Our Ref FP/27/10

Application for non-material amendment following the grant of planning permission FP/27/10 for a reduction in size and a revised roof design, together with various fenestrational alterations
11 Grafton Avenue, Felpham, Bognor Regis

DRAWING TITLE
Proposed Elevations & Floor Plans
Block Plan
Location Plan

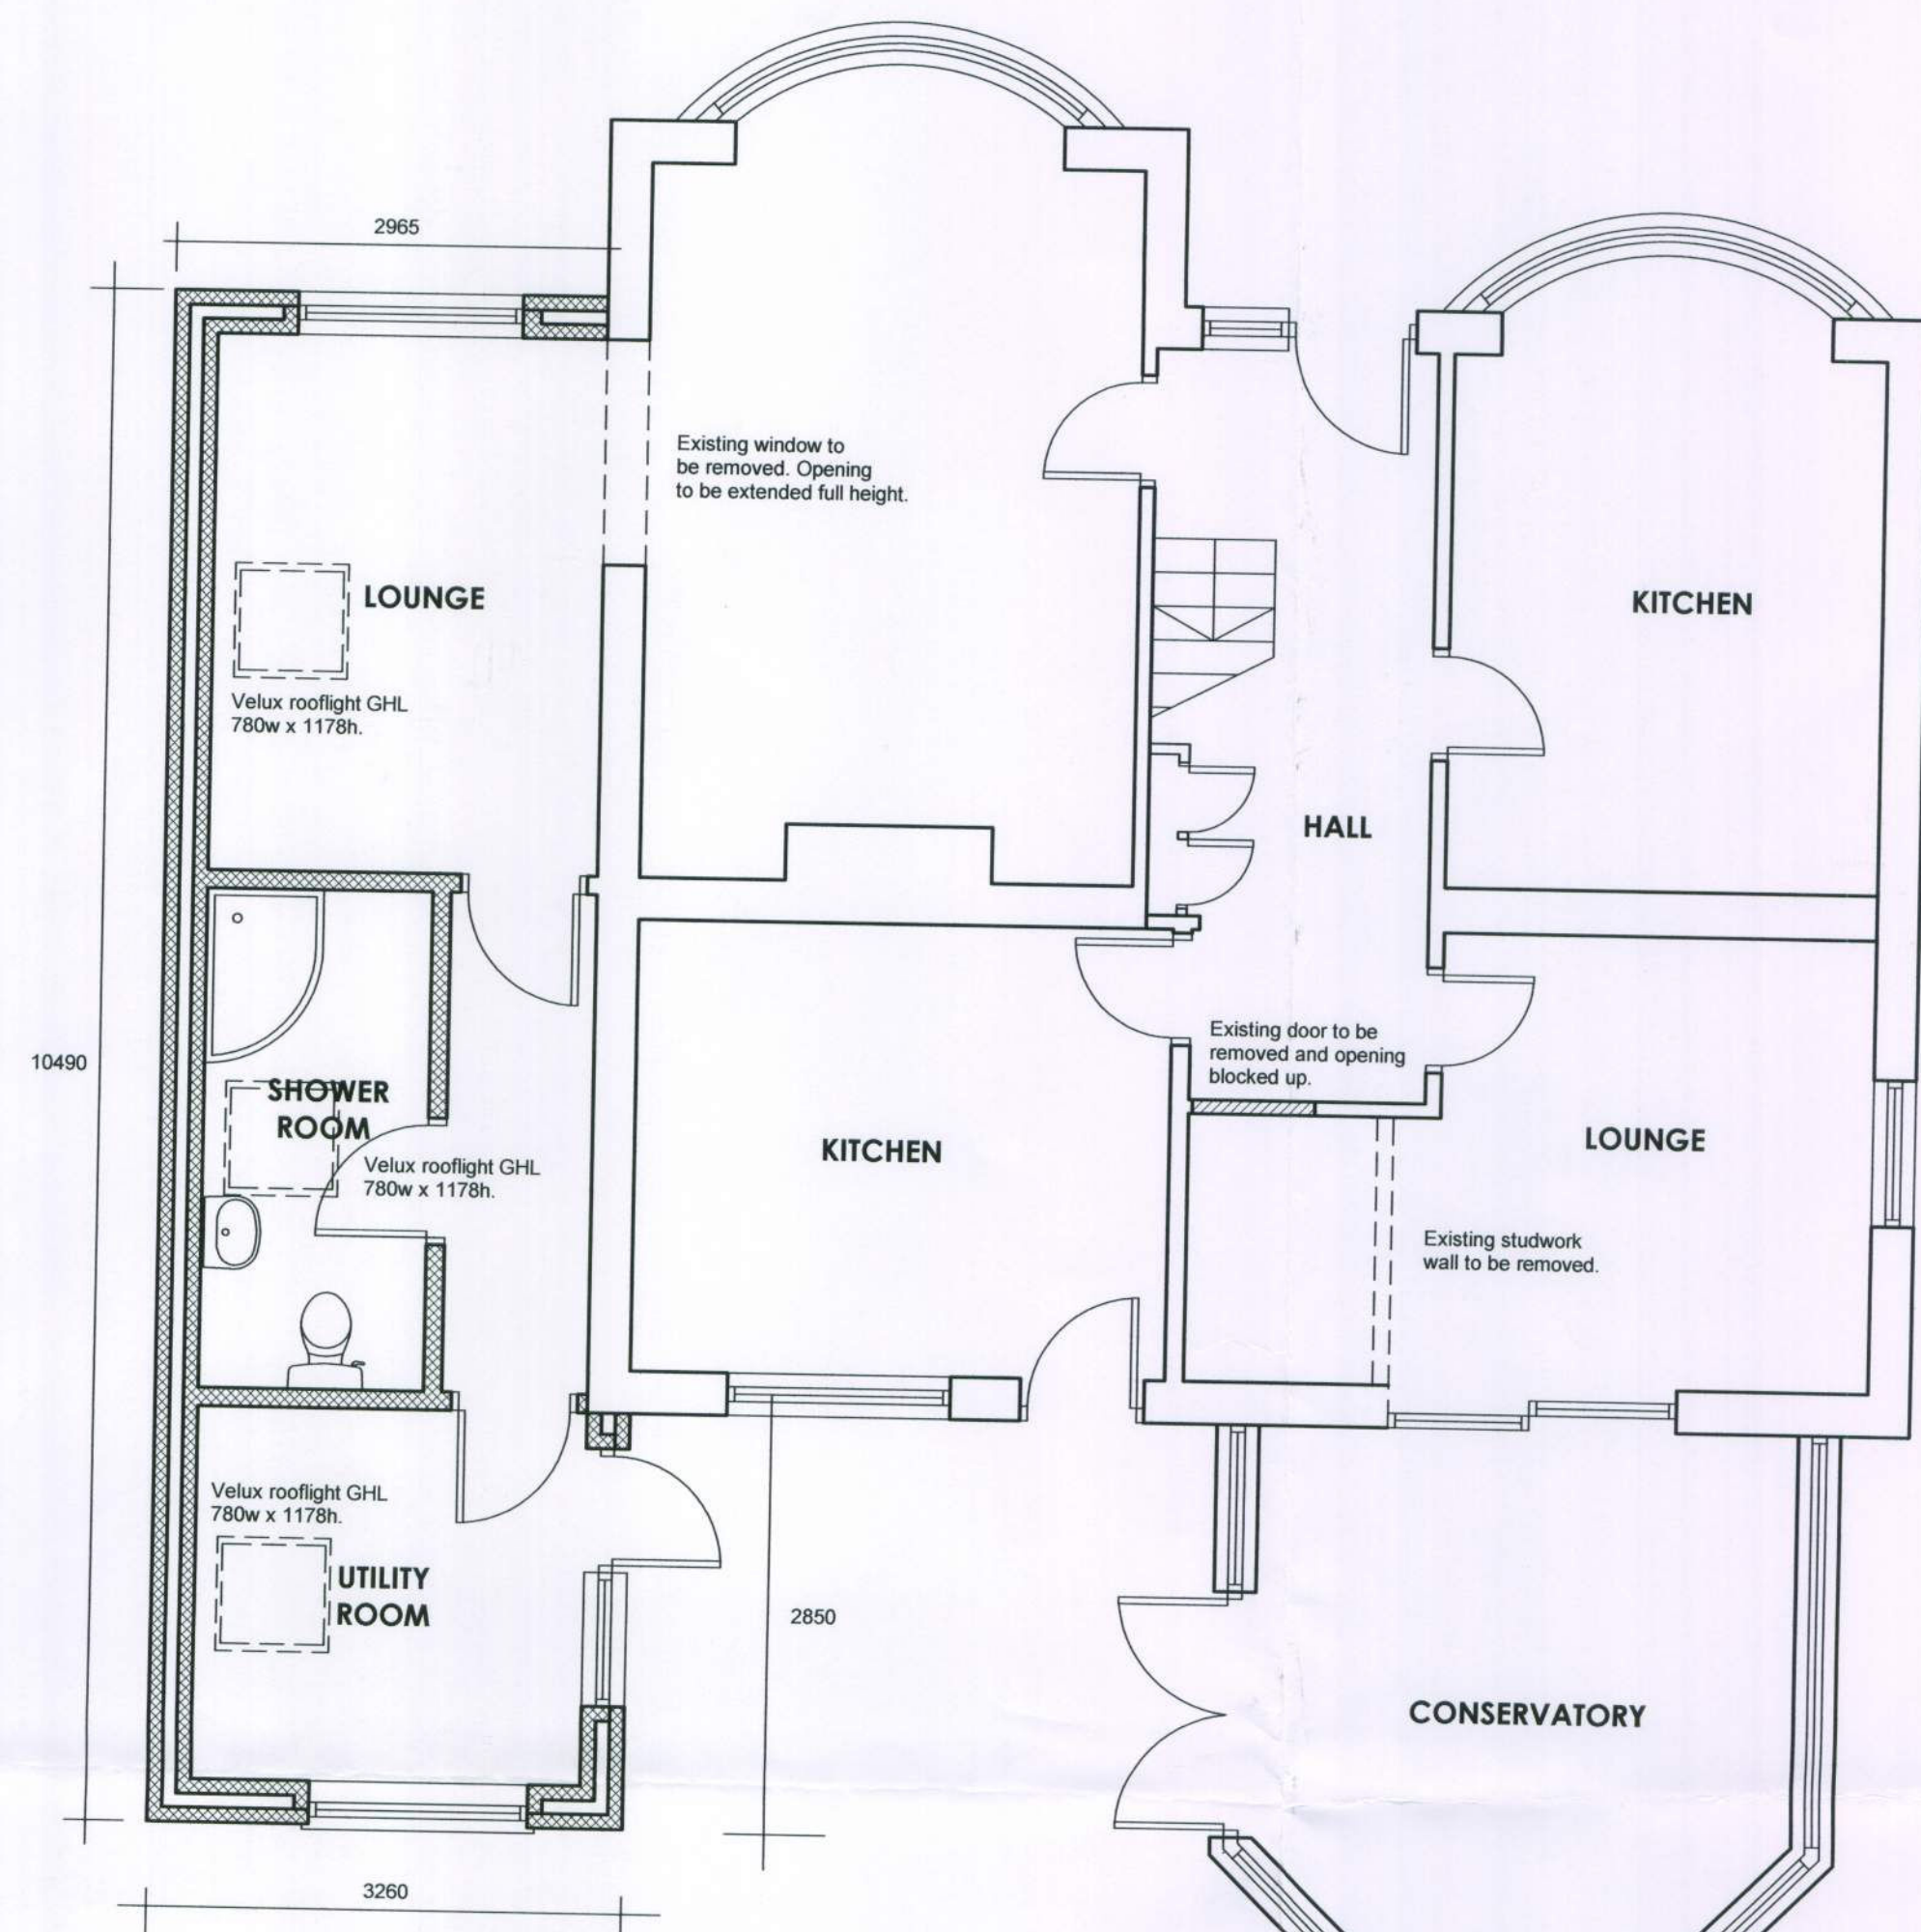
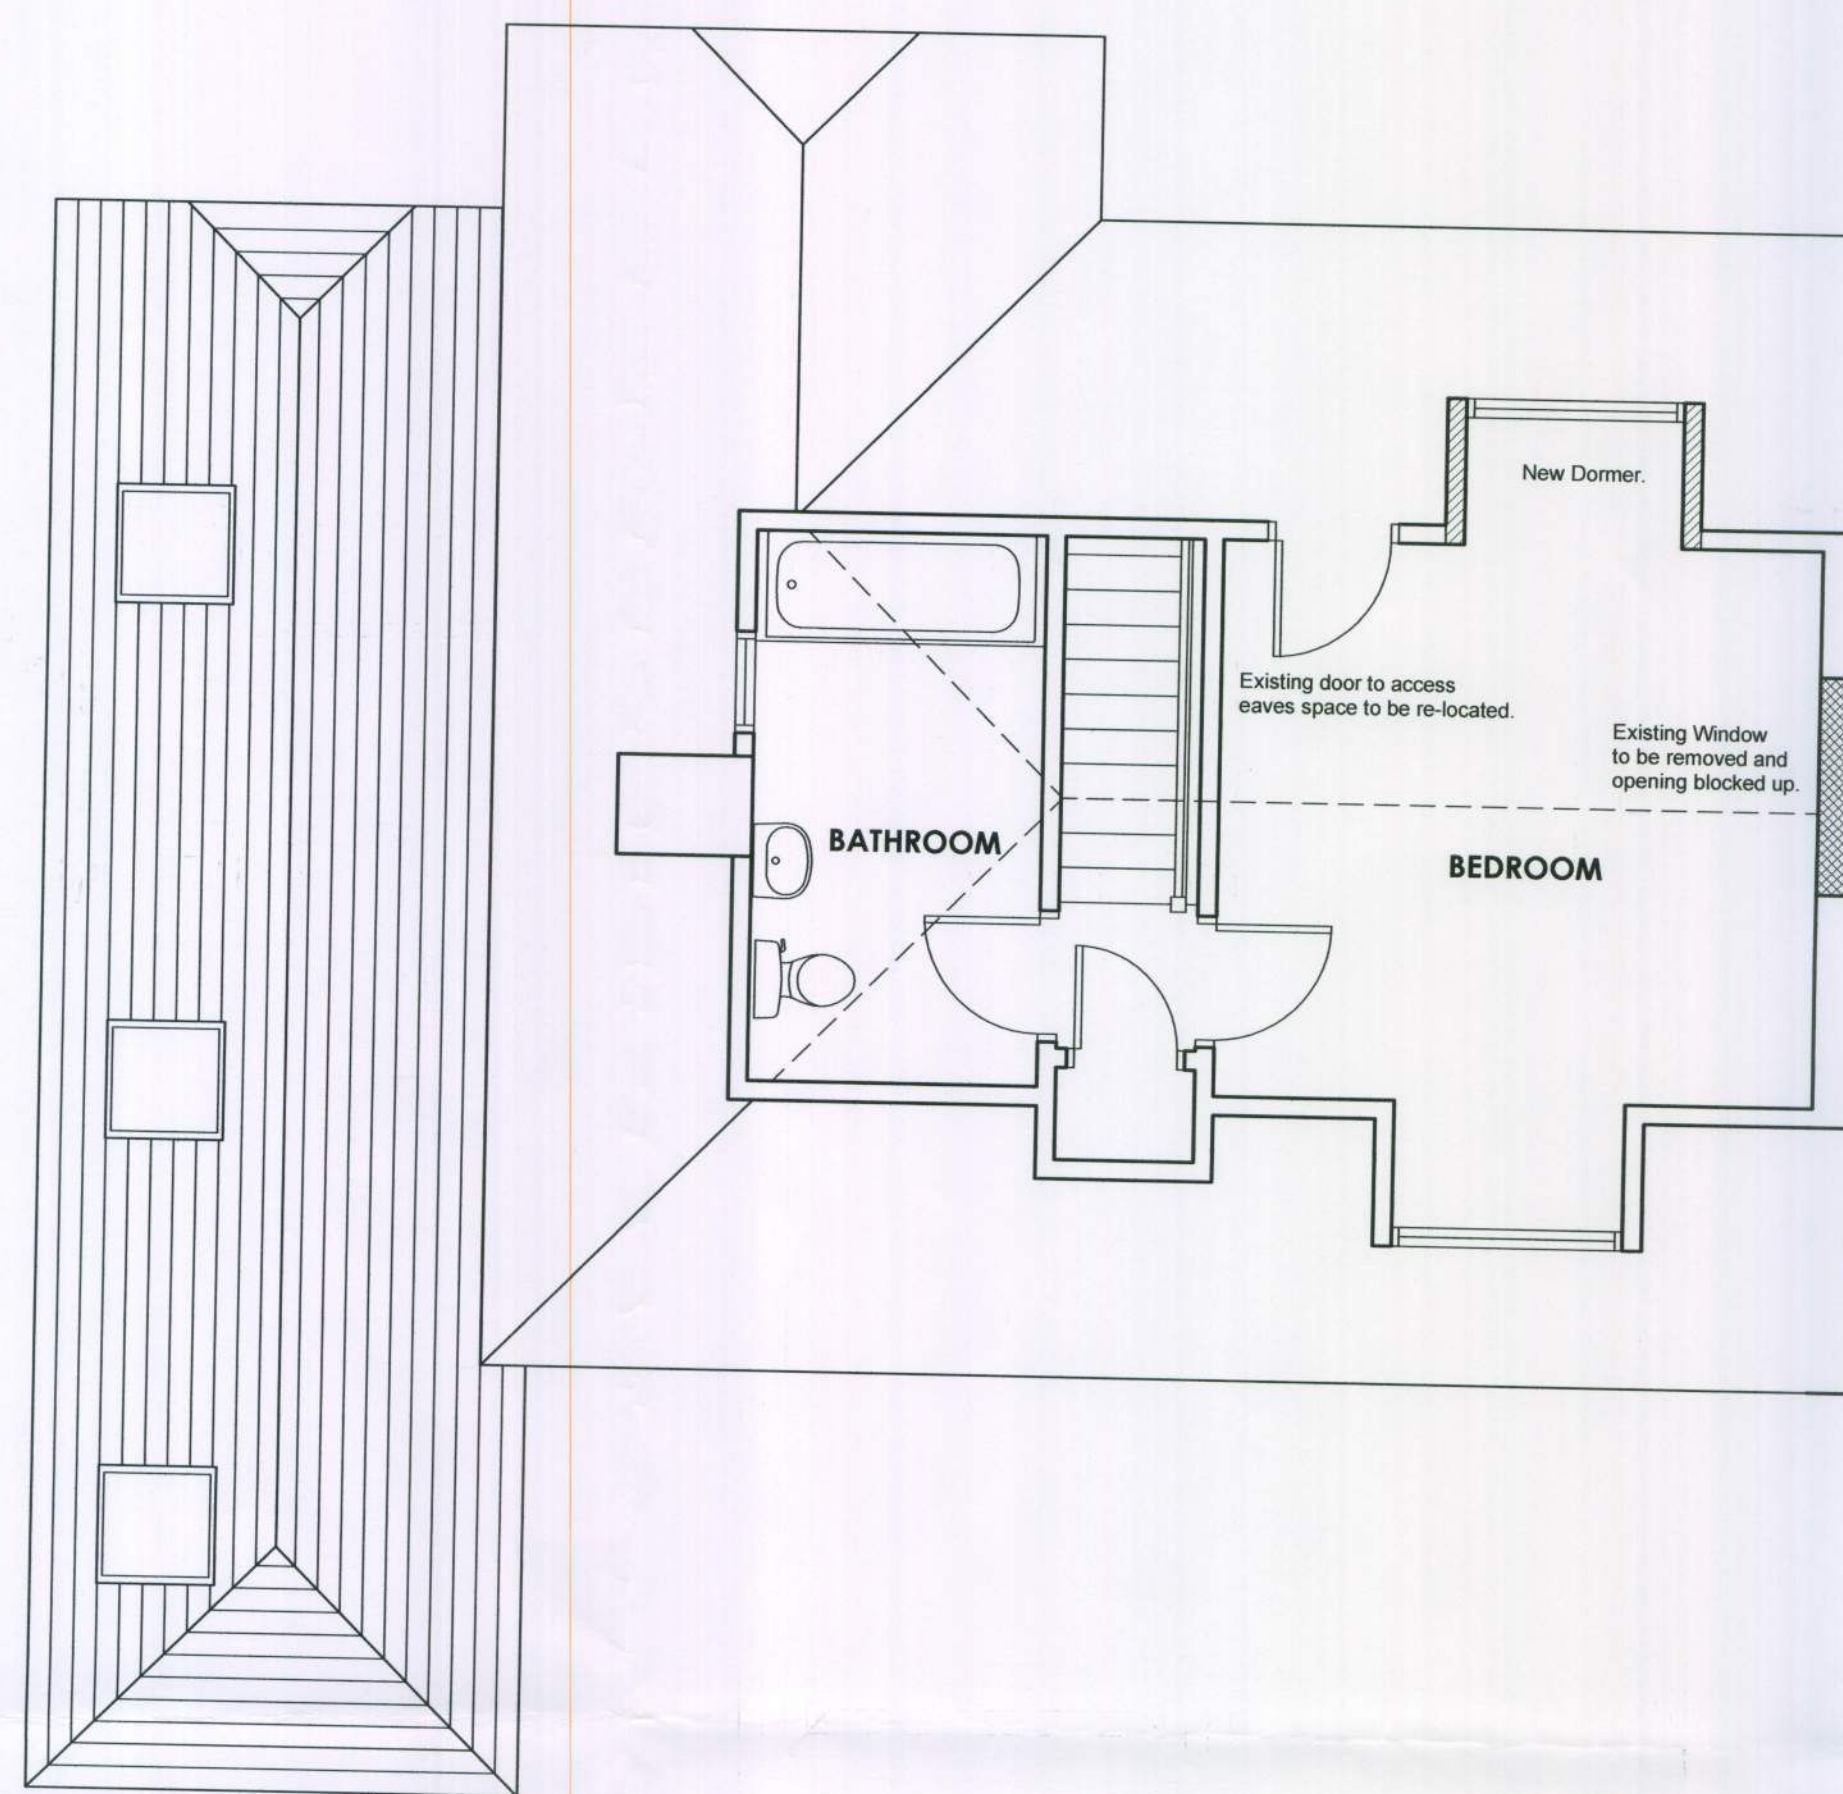
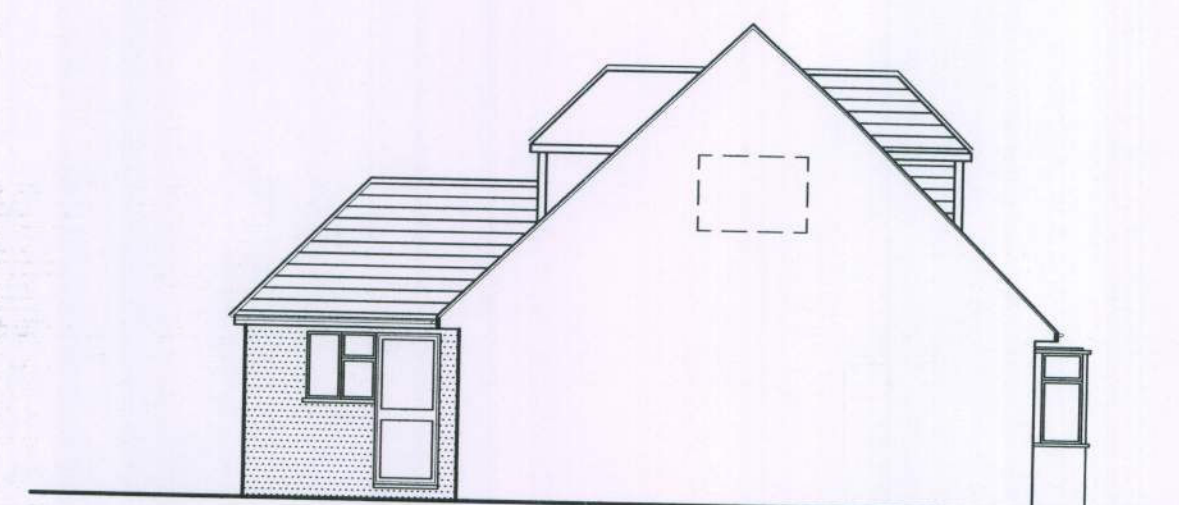
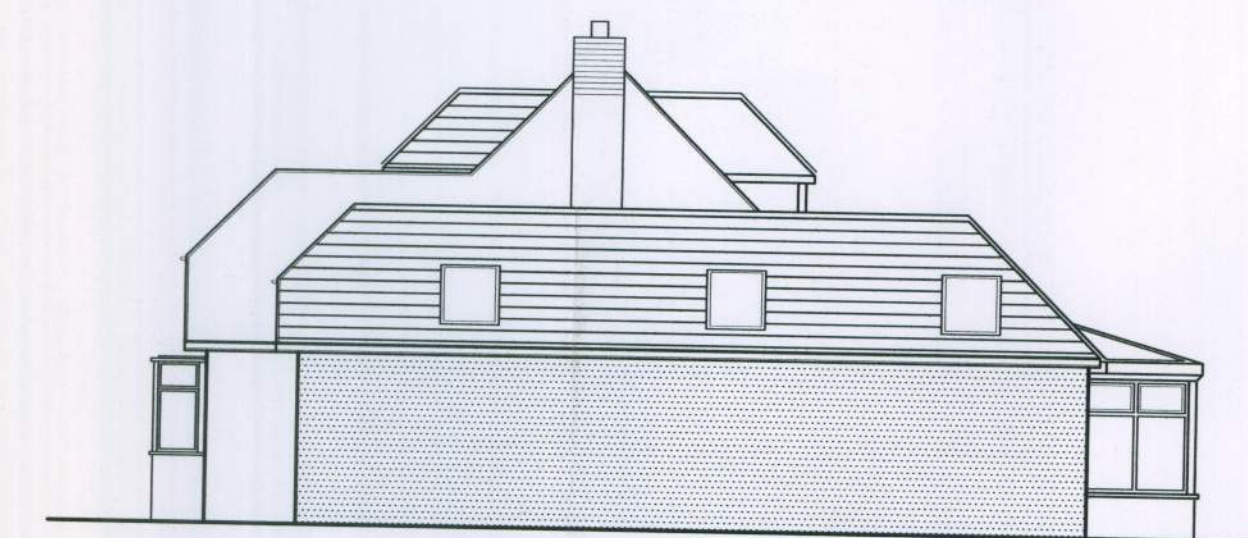
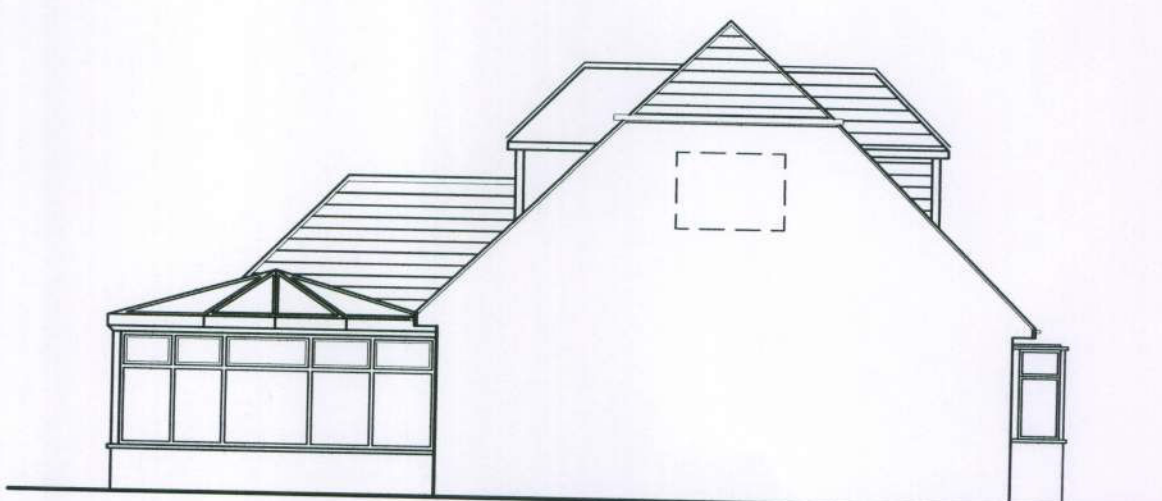
Thank you for your letter and enclosures received in this office on 9th June 2010. The changes identified from the approved plan namely to reduce the depth of the proposed extension, to alter the roof design, to remove a proposed window in the gable end of the property and to insert a roof light within the southern side elevation of the building, will be accepted as a minor amendment.

Please note that these plans therefore become the approved plans for planning application FP/27/10.
